From: Michael Eastham <Michael.Eastham@arun.gov.uk>
Sent: 13 May 2021 16:59
To: Planning.Responses <Planning.Responses@arun.gov.uk>
Subject: FW: Objection to Planning application WA/93/20/PL: Land East of Tye Lane, Walberton.

Objection to Planning application WA/93/20/PL: Land East of Tye Lane, Walberton.

Appendix B
Traffic Flow Diagrams

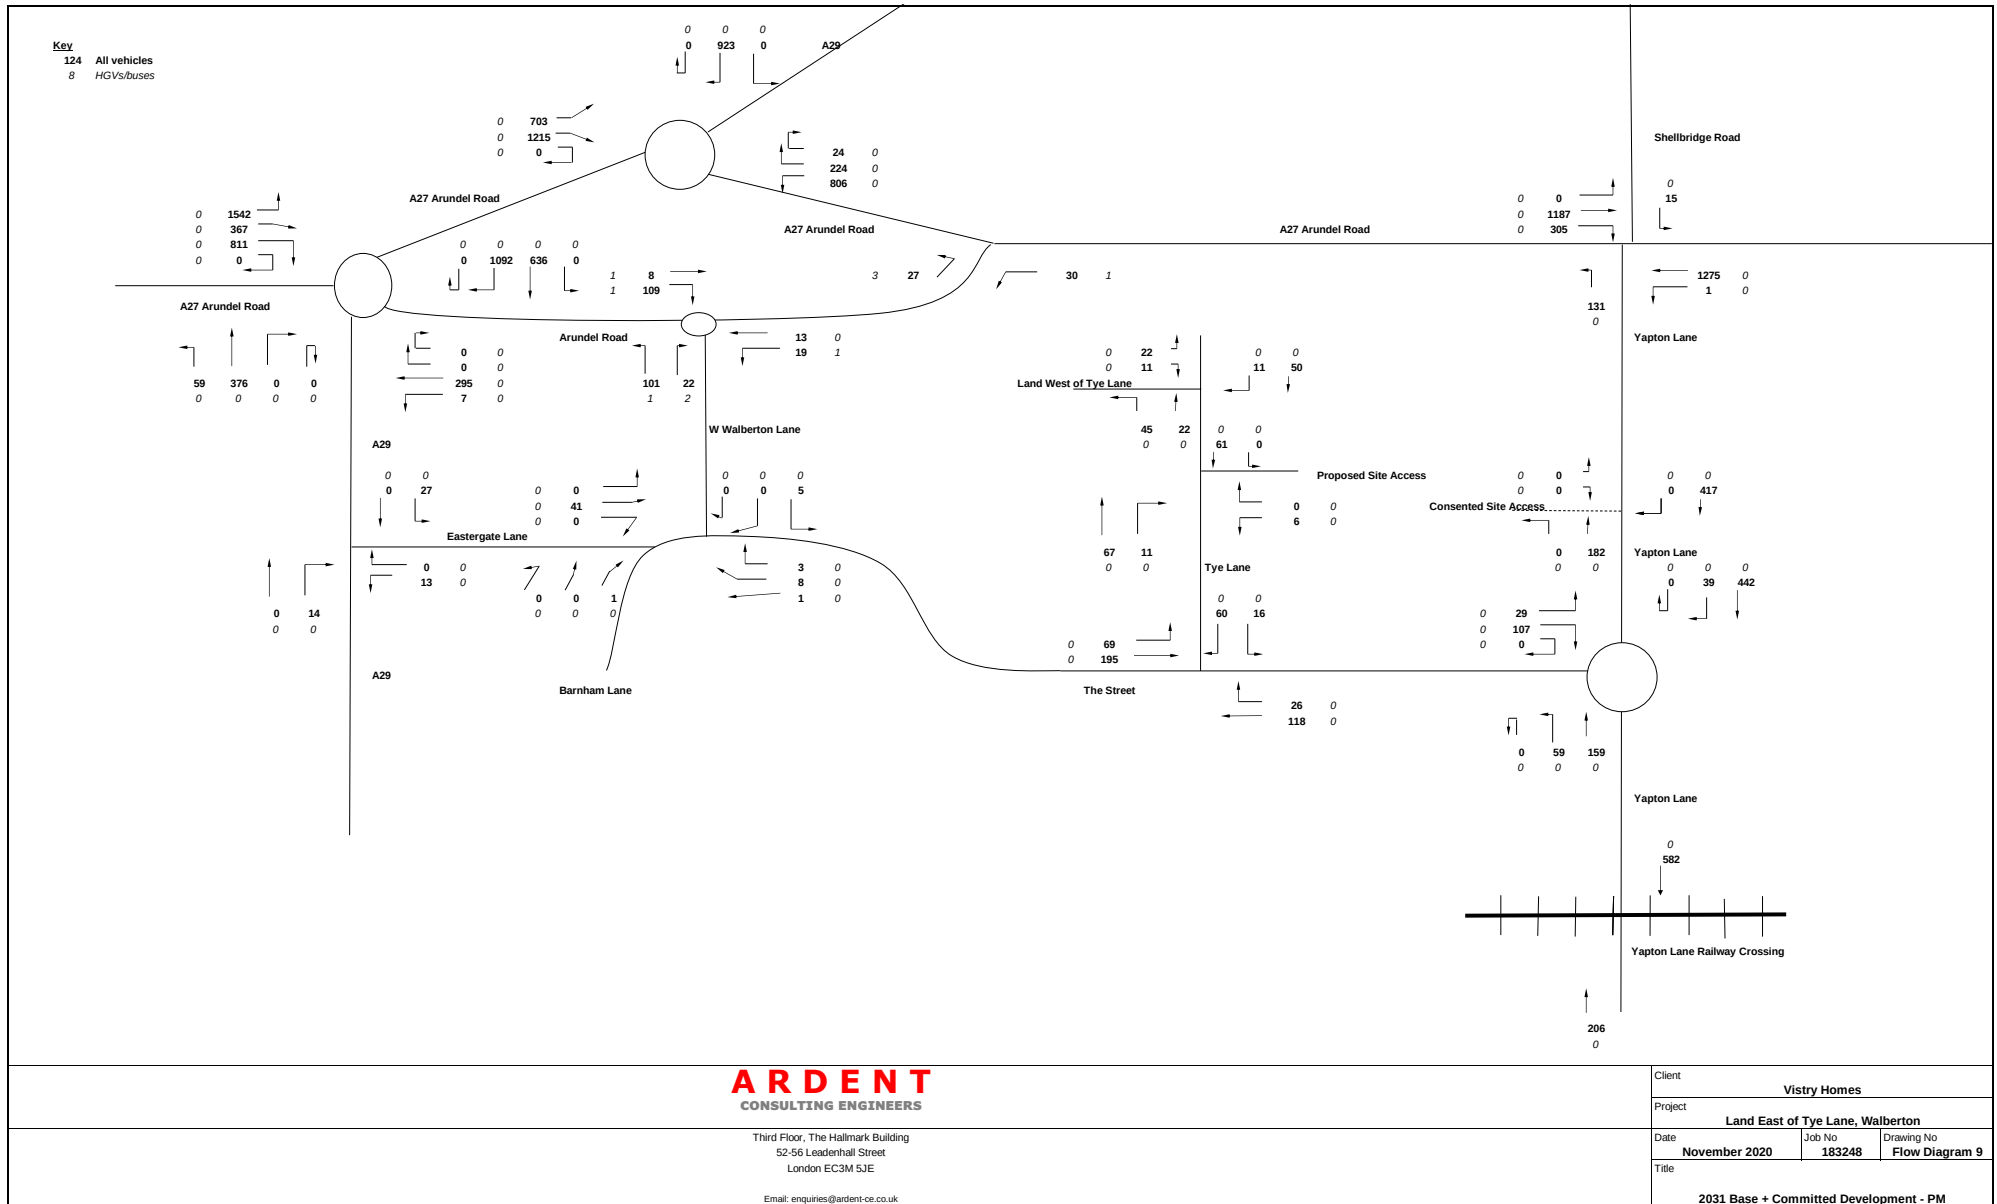
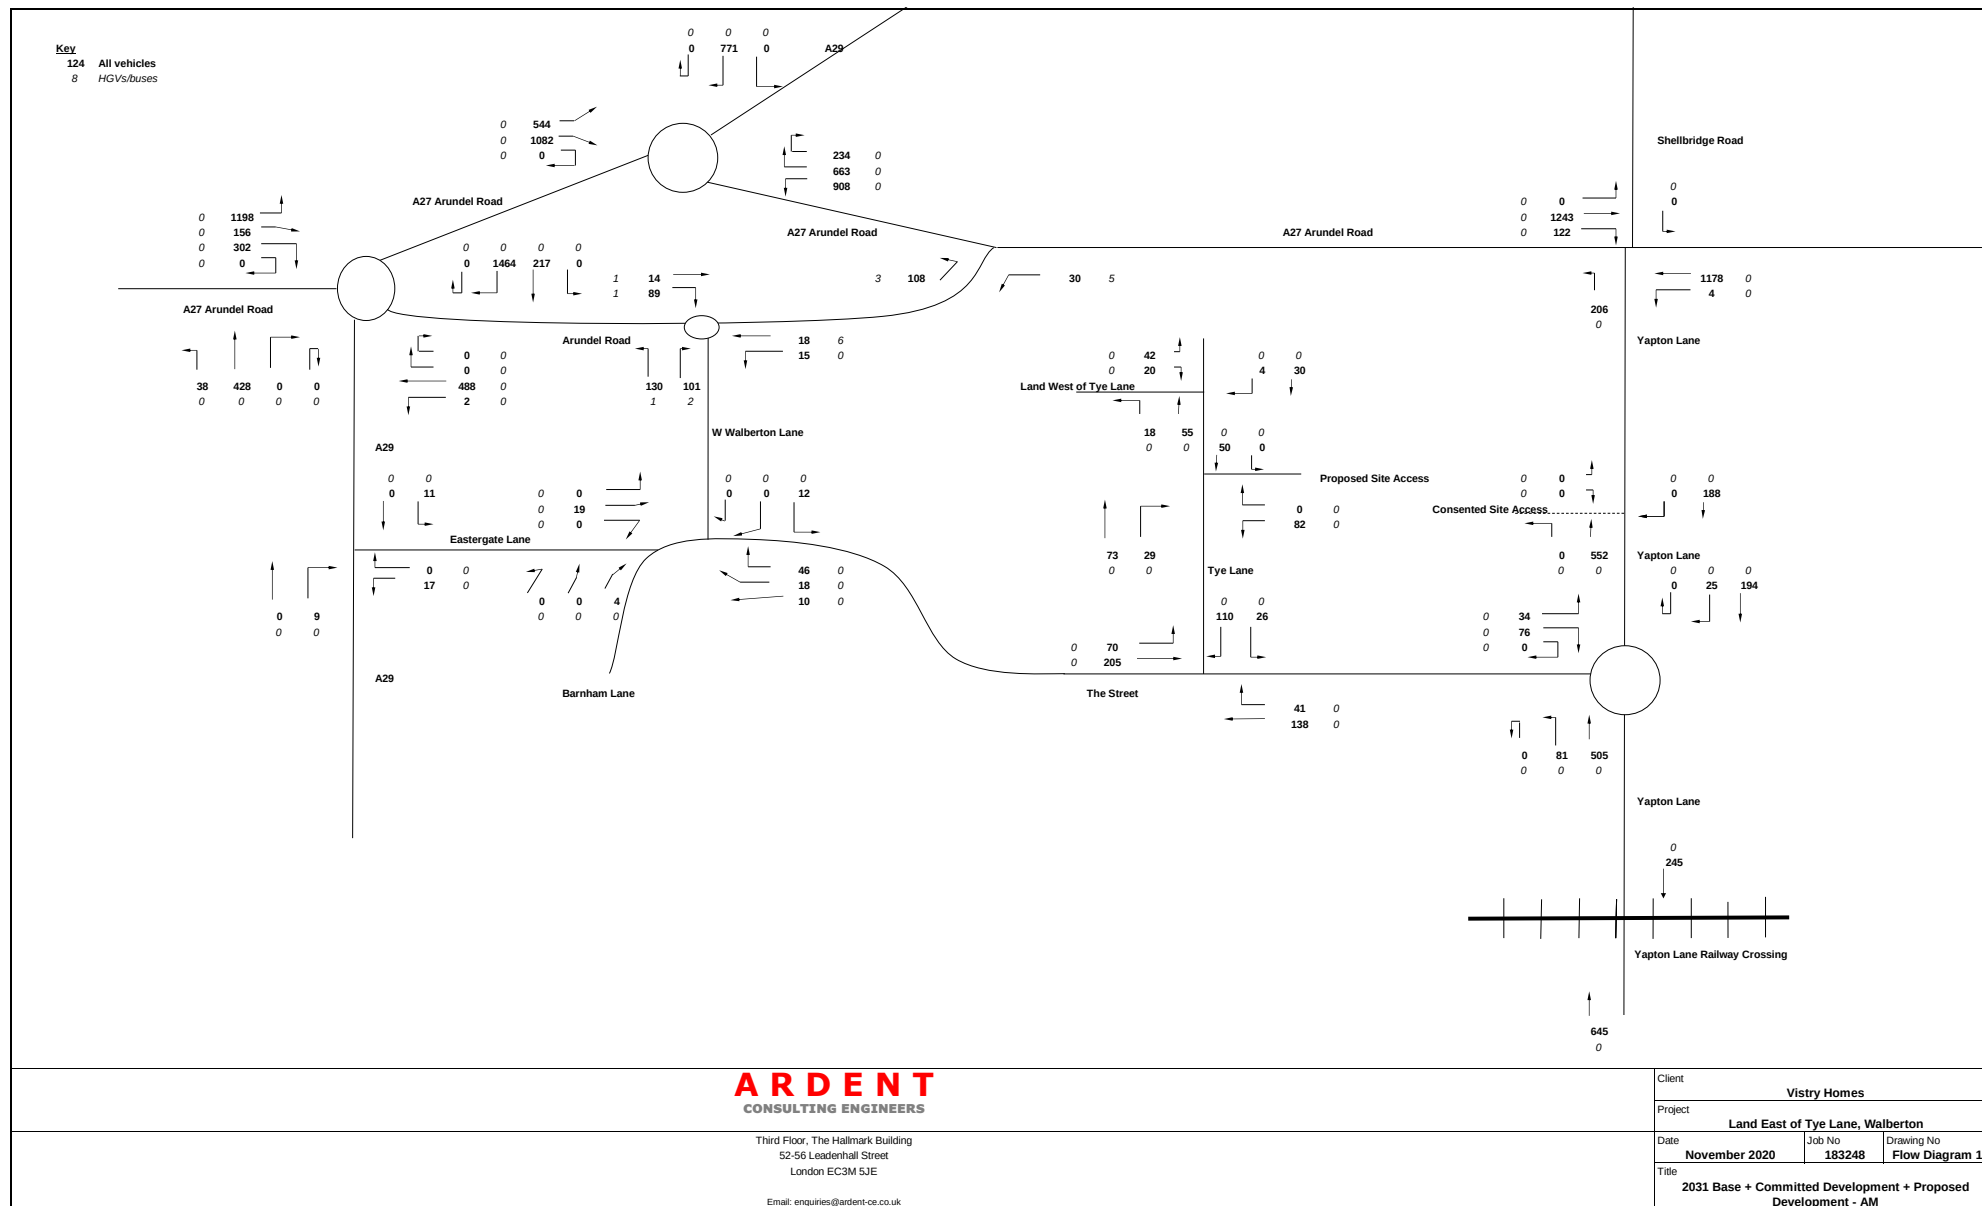
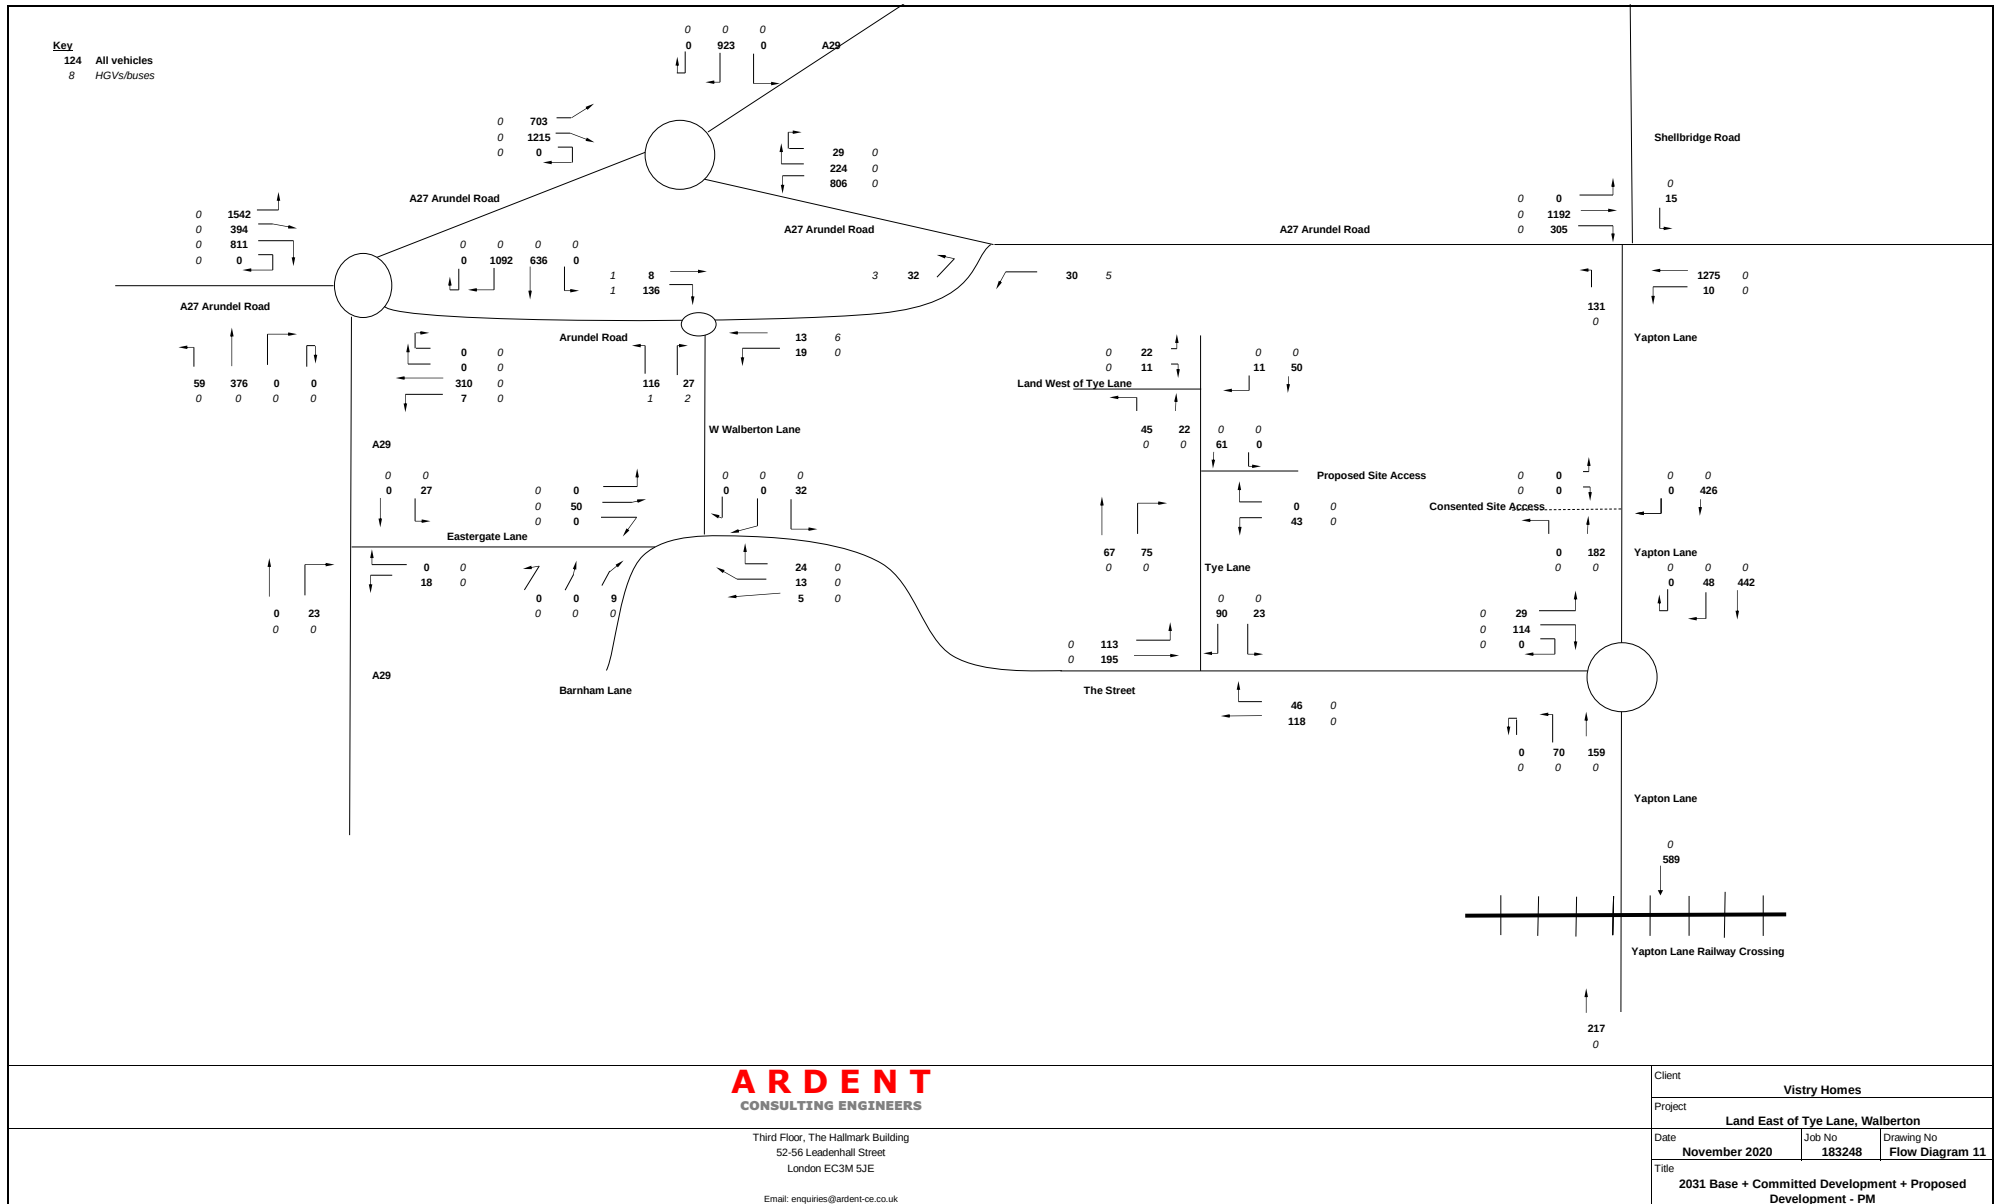
- A number of Traffic Flow Diagrams that are provided seem to have incorrect data. The 2031 base numbers used refer to 50 vehicles going northwards up Tye Lane to a dead end and 30 heading southbound from this dead end. Also, there would appear to be very few vehicle users predicted for 175 (soon to be 205) dwellings. The conclusion is that more traffic than described in the flow diagrams will be using local roads unsuited for this level of traffic. The application should be refused until correct information can be supplied, and the local impacts assessed.

AVISFORD PARK ROAD

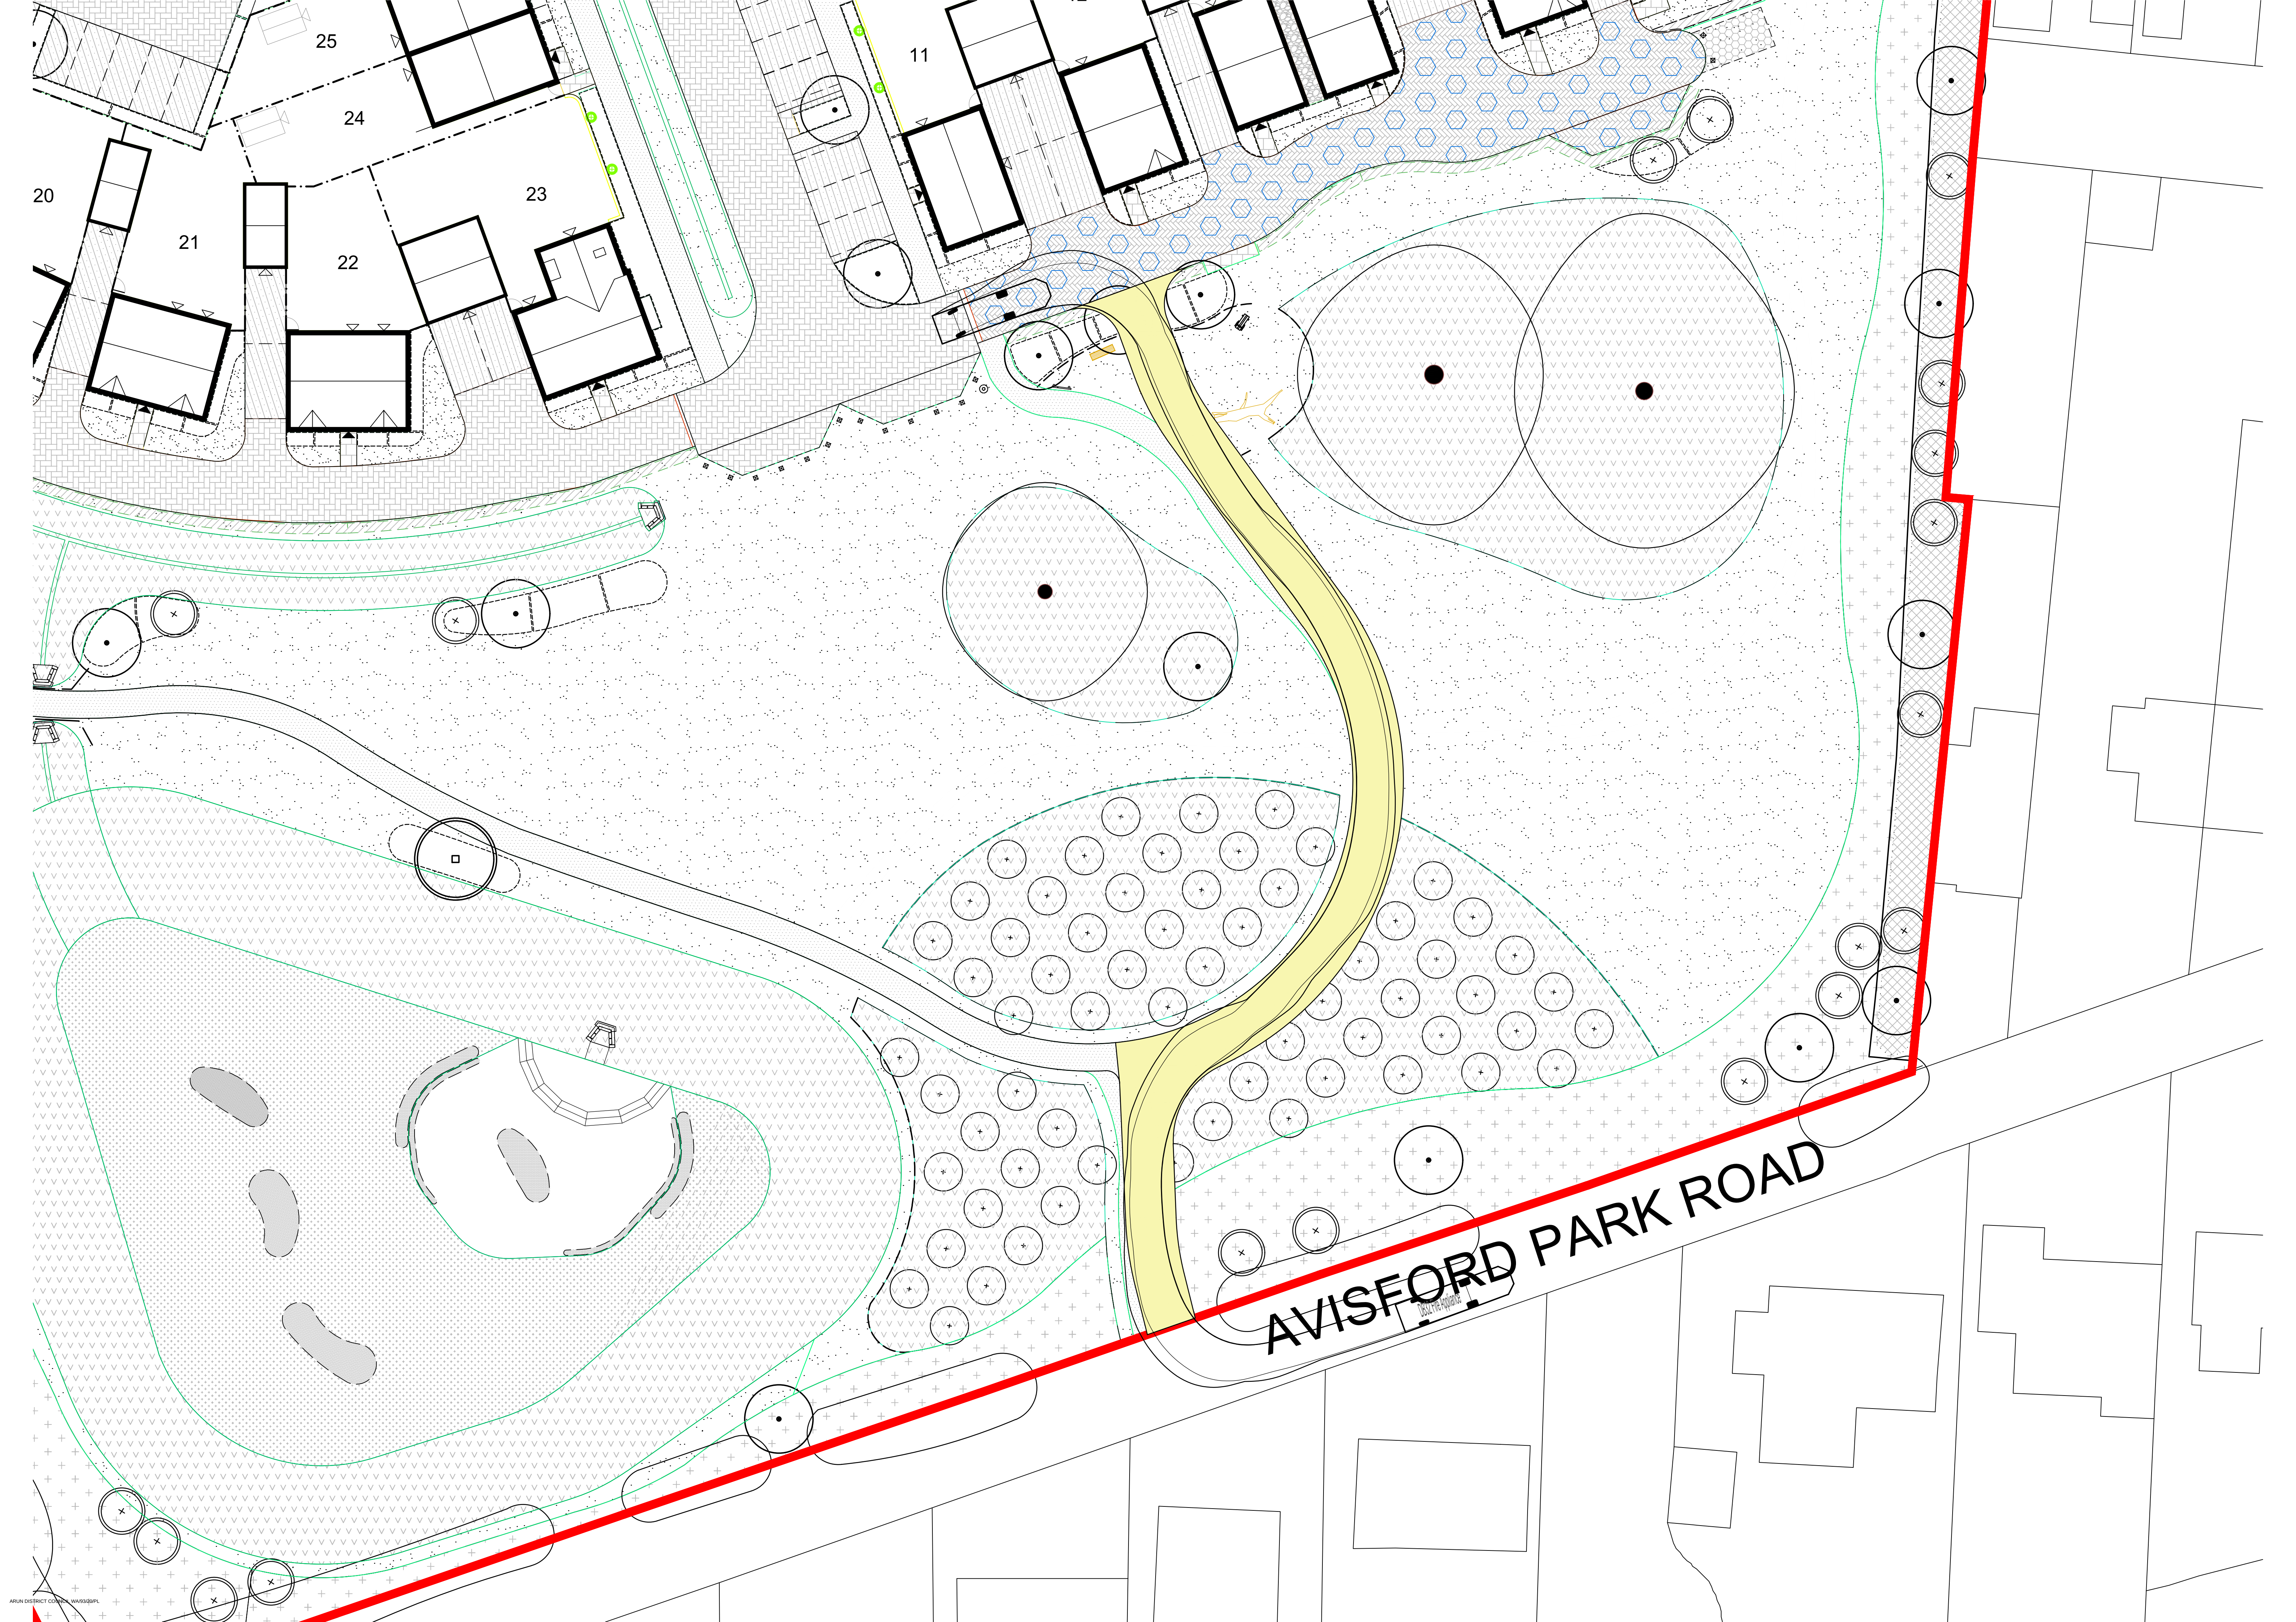
- I strongly object to the Avisford Park Road being used as an alternative emergency access as this is completely inappropriate and the planning application is inaccurate:

- o The application plan shows 2-way access into Avisford Grange development when Avisford Park Road is a single track un-adopted road that only has access from the Yapton Lane end. So, a left turn access into Avisford Grange would not be possible.

- o Avisford Park Road is single track, unsurfaced, un-adopted, and maintained by residents, which includes cutting back trees and hedges (not just on residents property) so that refuse vehicles can reverse down it. They reverse because there is nowhere to turn the vehicle within the road. There are no passing places in the road.
